East
Northamptonshire
Council

Please ask for	Direct Dial	Our Reference	Your Reference	Date
Erika Davies Planning Services	01832 742207	NE/21/00003/FUL	PP-09335430	7 January 2021

Proposal : First floor side extension above existing ground floor side extension. at 35
Park Road Irthlingborough Wellingborough Northamptonshire NN9 5PW

DRAWING TITLE: EXISTING DRAWINGS

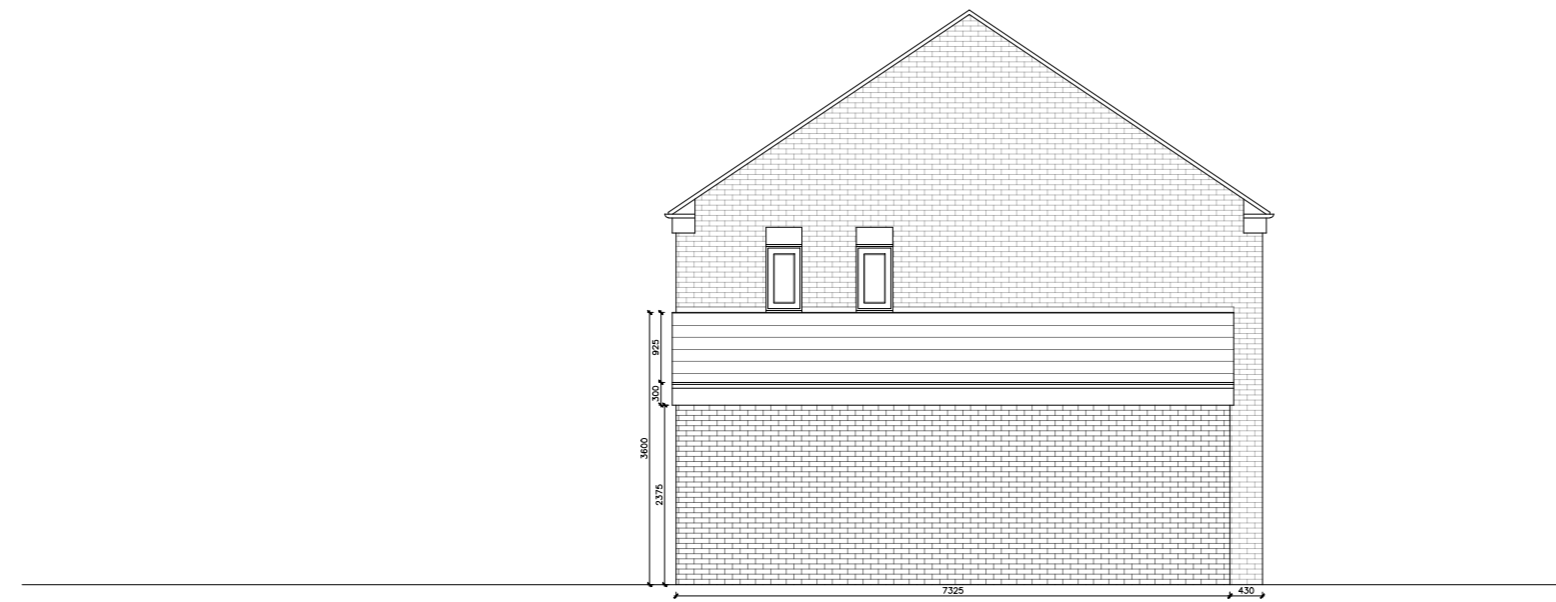
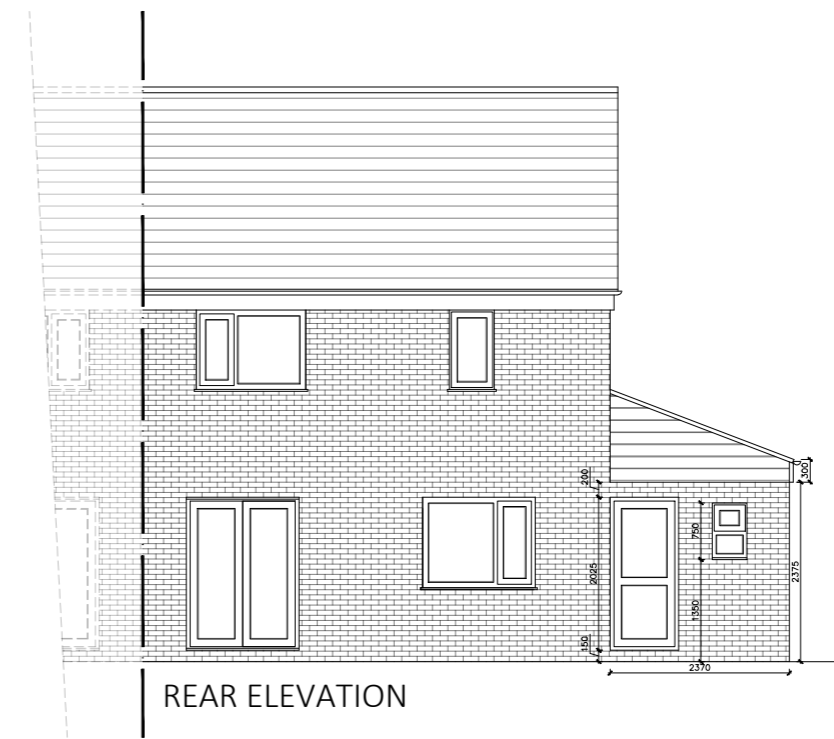
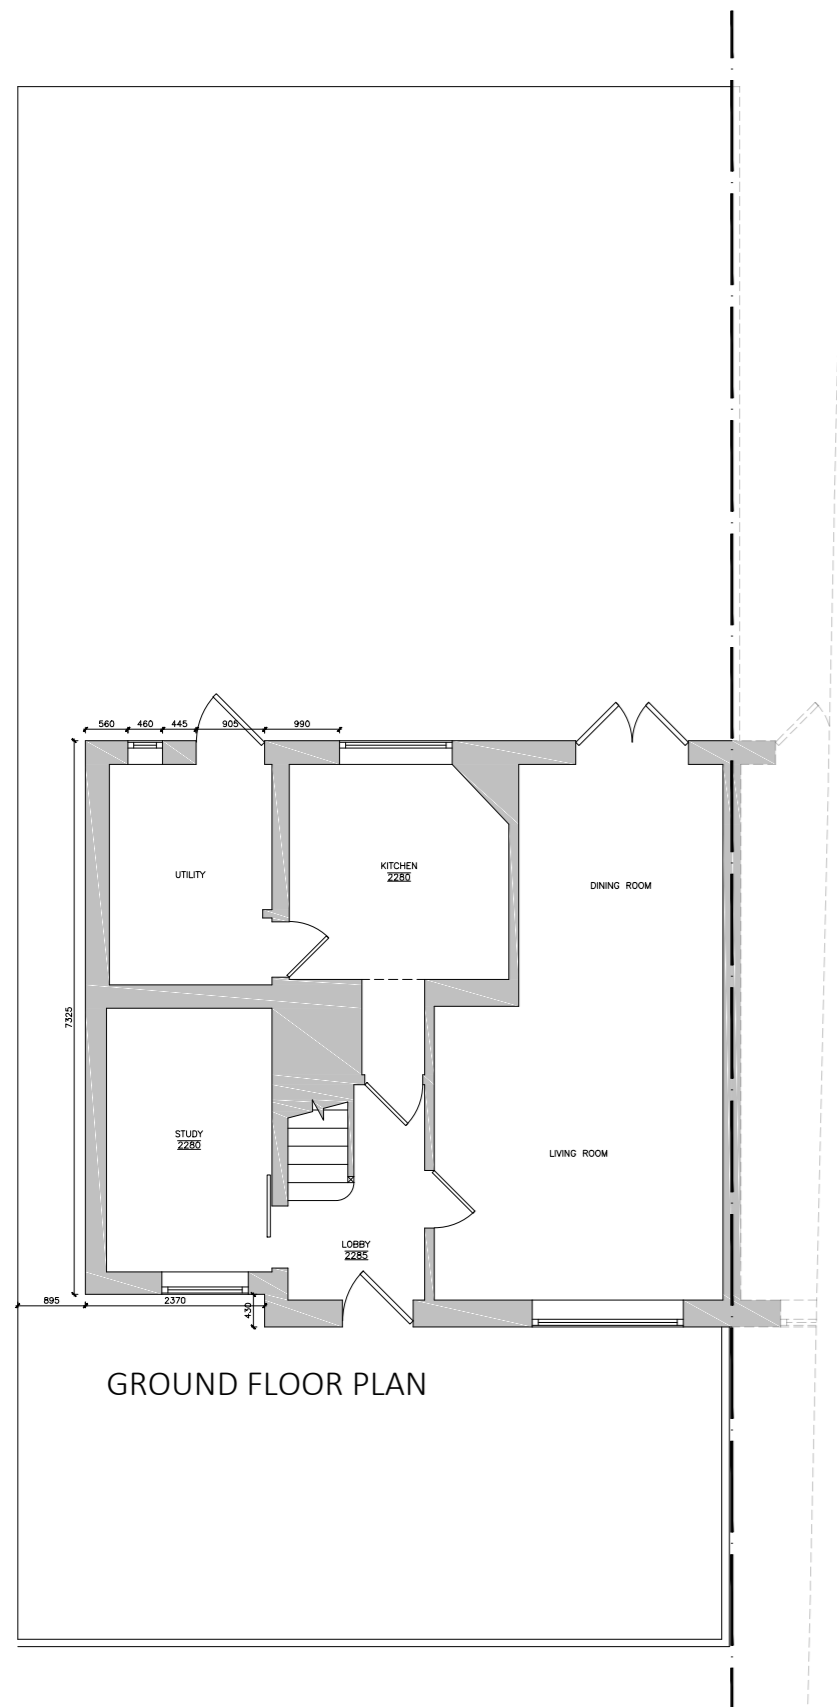
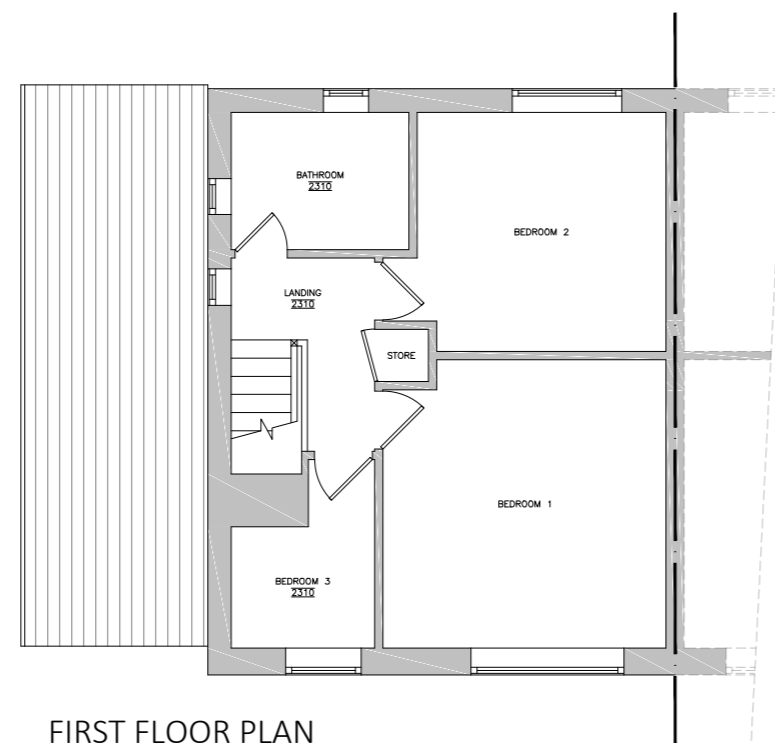
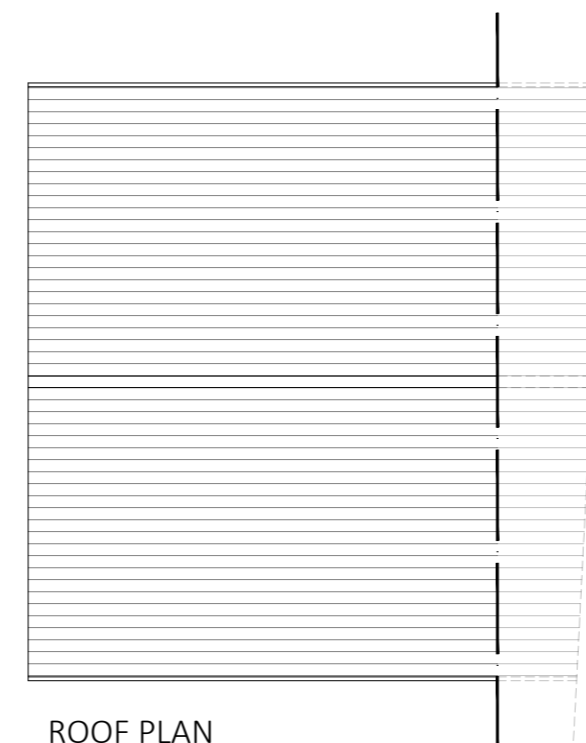
2. Drawings should be accurate. Ambiguous statements such as "Do not scale", "Not to scale" etc. call the accuracy of the drawing into question and therefore cannot be accepted. Please remove the "Do not scale" legend of the drawings or give written consent for this to be removed.

Please provide amended drawings including all relevant dimensions of the proposal:

- Dimensions for the existing and proposed floor plan
- Dimensions for the existing and proposed elevations annotated with all height dimensions
